**From:** Tom Errico <thomas.errico@tylin.com>  
**To:** Jean Fraser <JF@portlandmaine.gov>  
**CC:** David Margolis-Pineo <DMP@portlandmaine.gov>, "Earley, Katherine" <KAS@p...>  
**Date:** 7/8/2014 9:26 AM  
**Subject:** 122 Anderson Street - Preliminary Traffic Comments

Jean - The following represents my preliminary traffic comments for the project.

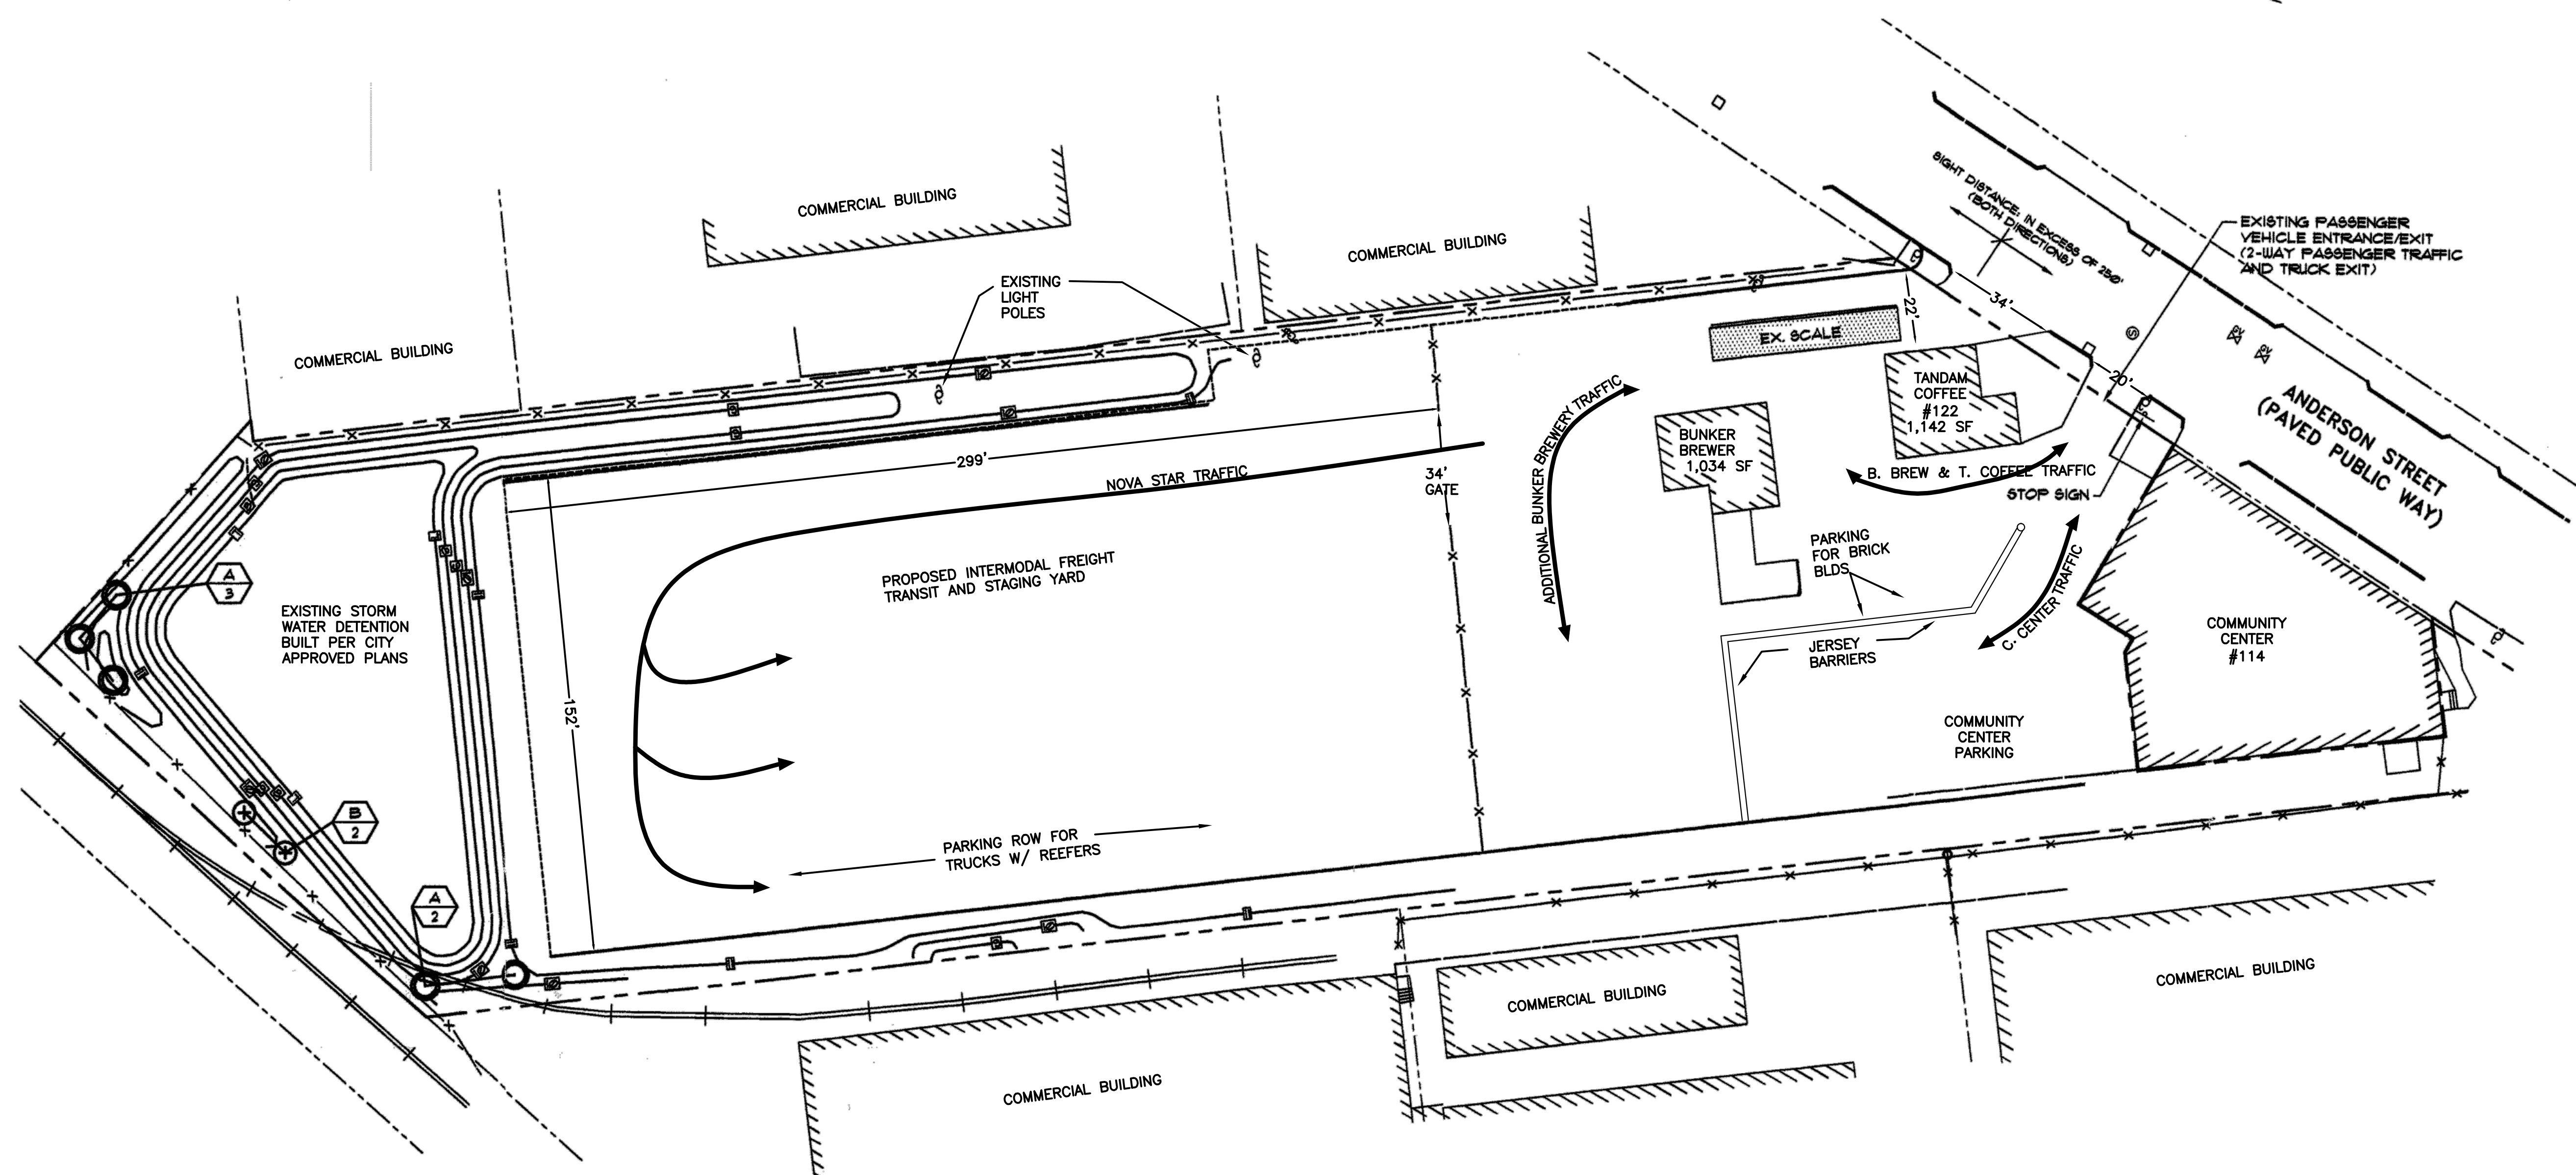
- \* The applicant should provide dimensions for the project driveway and entrance roadway into the site.
- \* Current signage at the proposed driveway indicates left-turns from the driveway are prohibited and that it functions as an entrance only. The applicant should provide details on the use of the driveway and how it serves Tandem Coffee and Bunker Brewing Company (And how does the driveway to the south serve these uses).

- \* The applicant shall provide details on a specific truck routing plan between the proposed site and the Nova Star and between I-295 and the site. Given the geometry of the driveway, trucks would be best served for left-turn only entry movements and right-turn only exit movements. My general sense is that movements from Franklin Street along Fox Street to Anderson Street is the most appropriate routing.

- \* The angle of the driveway should be reviewed as it relates to City standards and determined if a waiver is required.
- \* The project driveway does not meet City driveway separation standards. The applicant will need to formally request a waiver from the technical standards with supporting documentation.
